WEST SUSSEX COUNTY COUNCIL CONSULTATION

TO:	Arun District Council FAO: Amber Willard
FROM:	WSCC - Highways Authority
DATE:	4 December 2020
LOCATION:	16 North End Road Arundel BN18 0DJ
SUBJECT:	Y/129/20/HH Installation of vehicular crossover.
DATE OF SITE VISIT:	n/a
RECOMMENDATION:	More Information
S106 CONTRIBUTION TOTAL:	n/a

GA front access

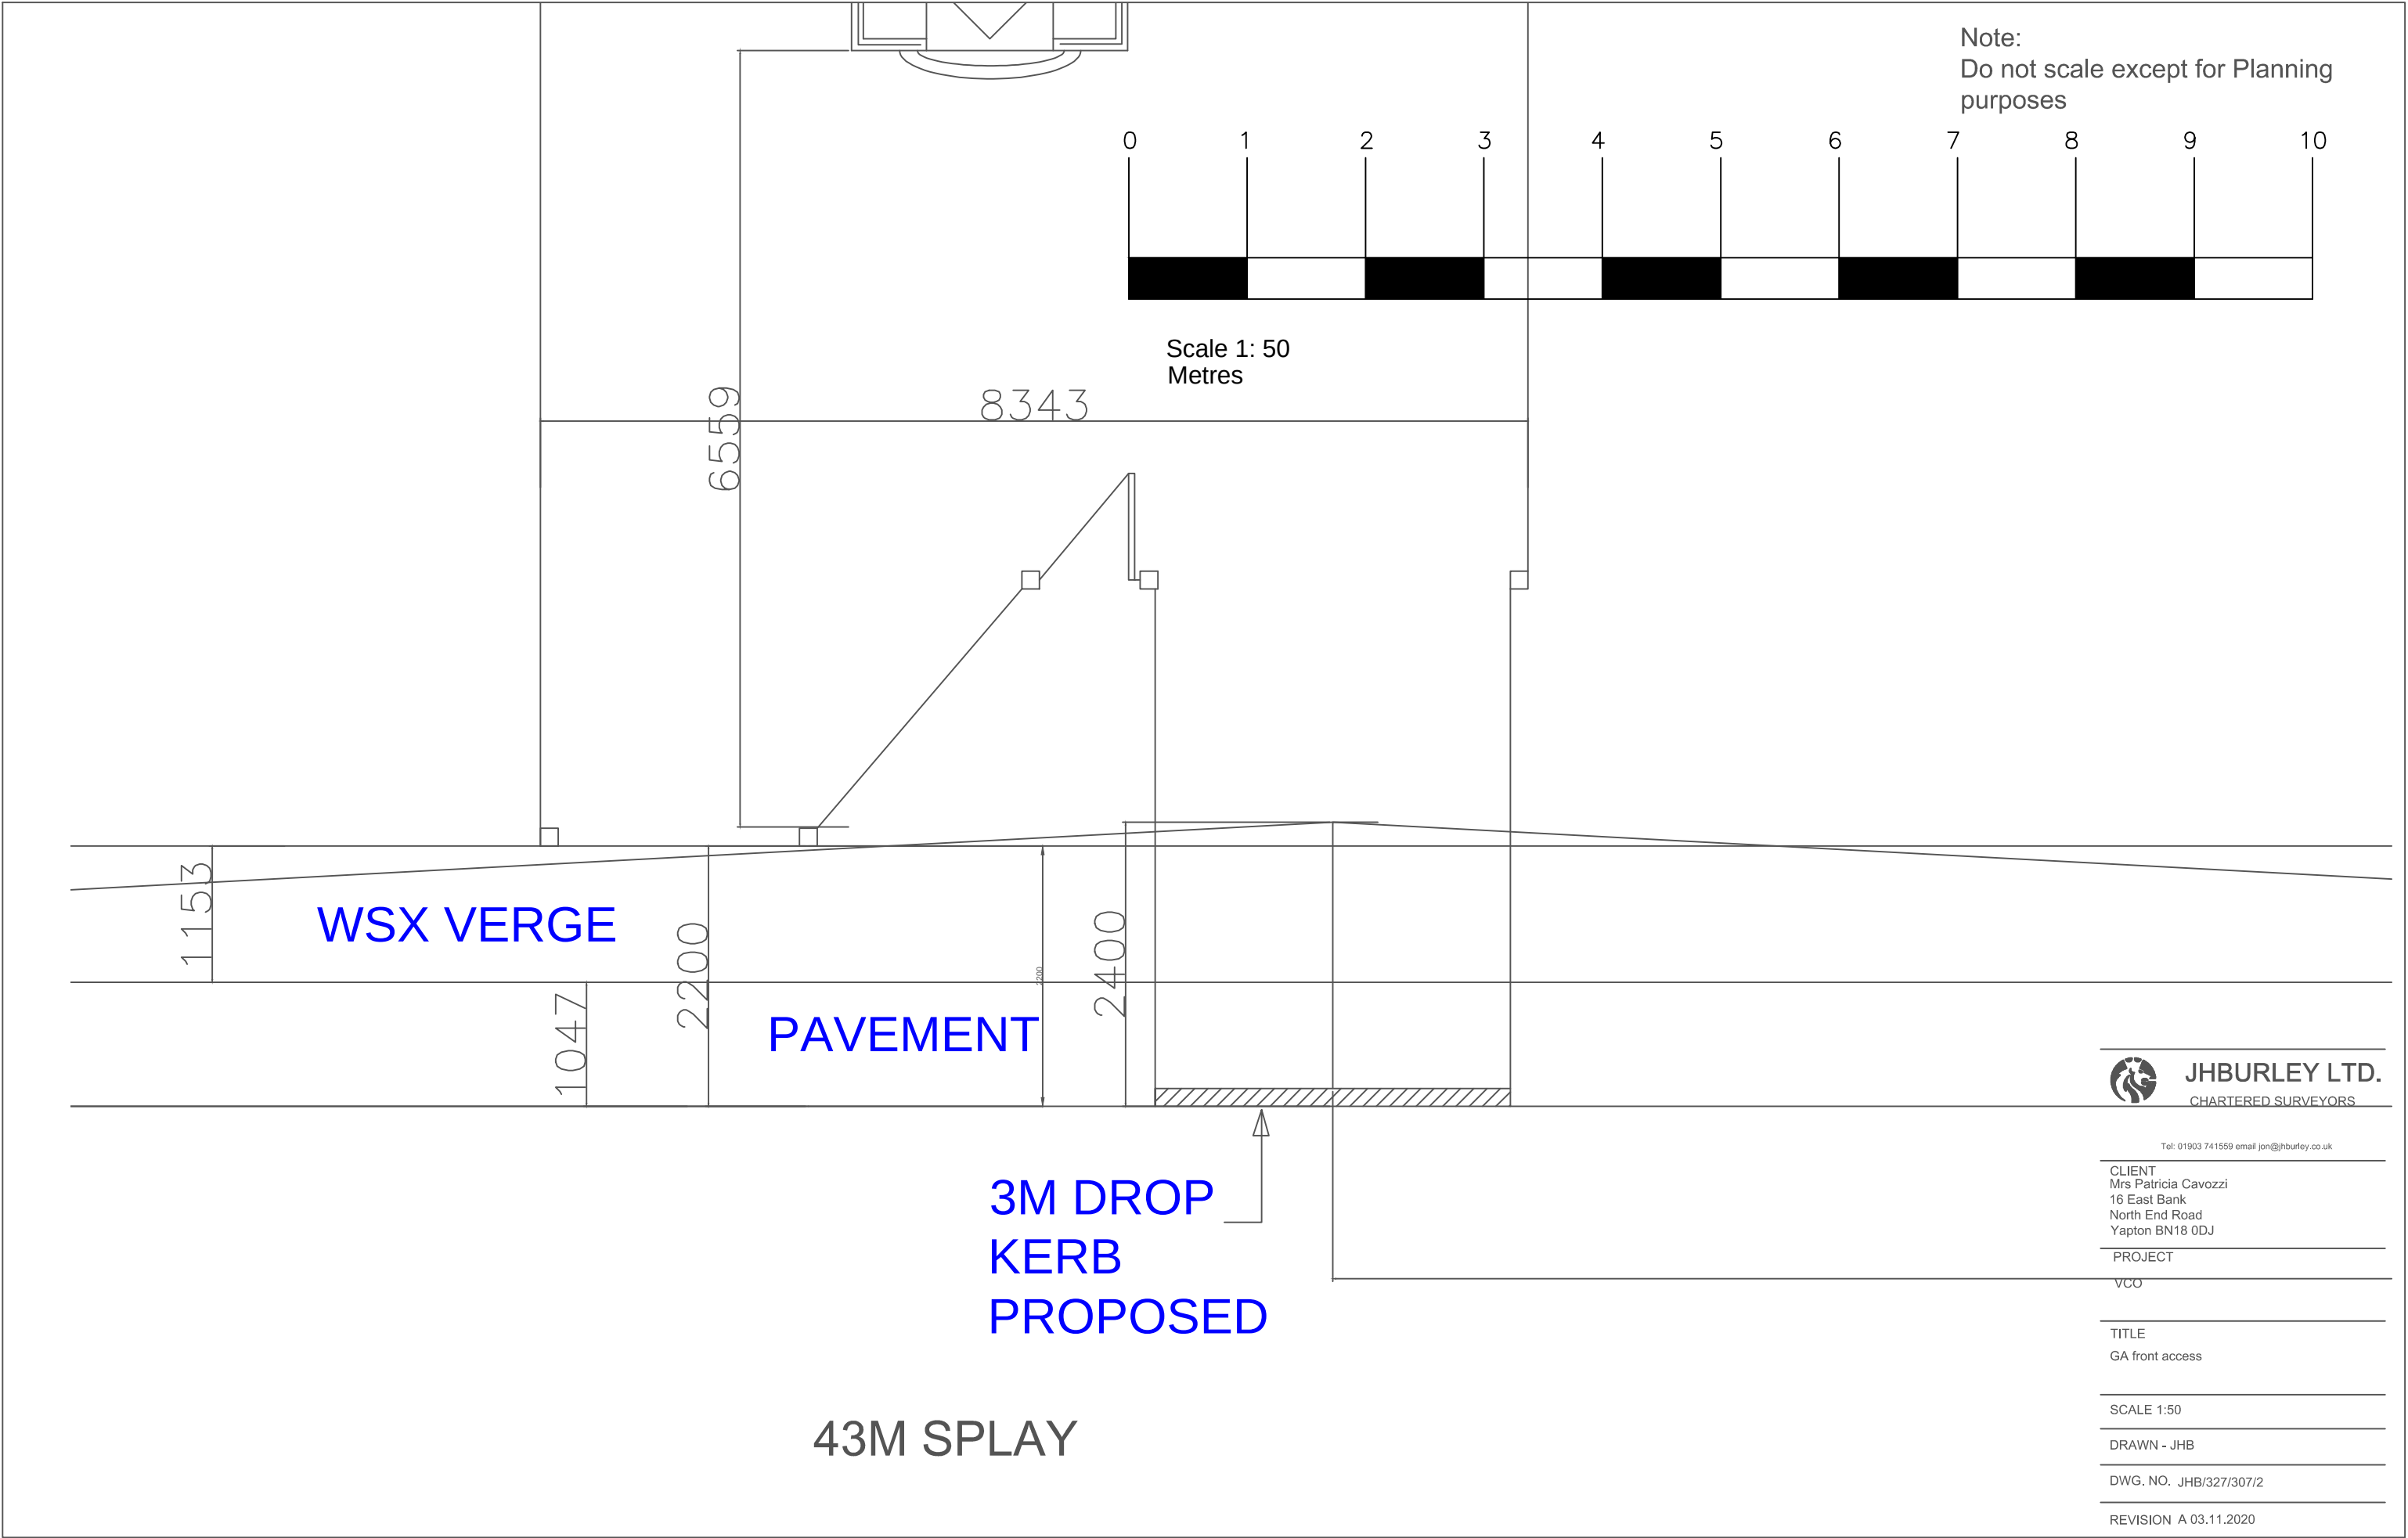
The applicant has proposed a new access.

Visibility splays have not been provided alongside this most recent application, the Local Highways Authority (LHA) therefore advise the applicant to provide maximum achievable visibility splays for the proposed access point.

All Visibility splays must include a 2.4 metre setback distance from the kerb edge and span in both directions to no more than 1 metre from the kerbed edge. The splays must

not intersect third party land, be located solely within land under the control of the applicant or within the Publicly Maintained Highway and include the current road geometry. We have provided a diagram below for your guidance only.
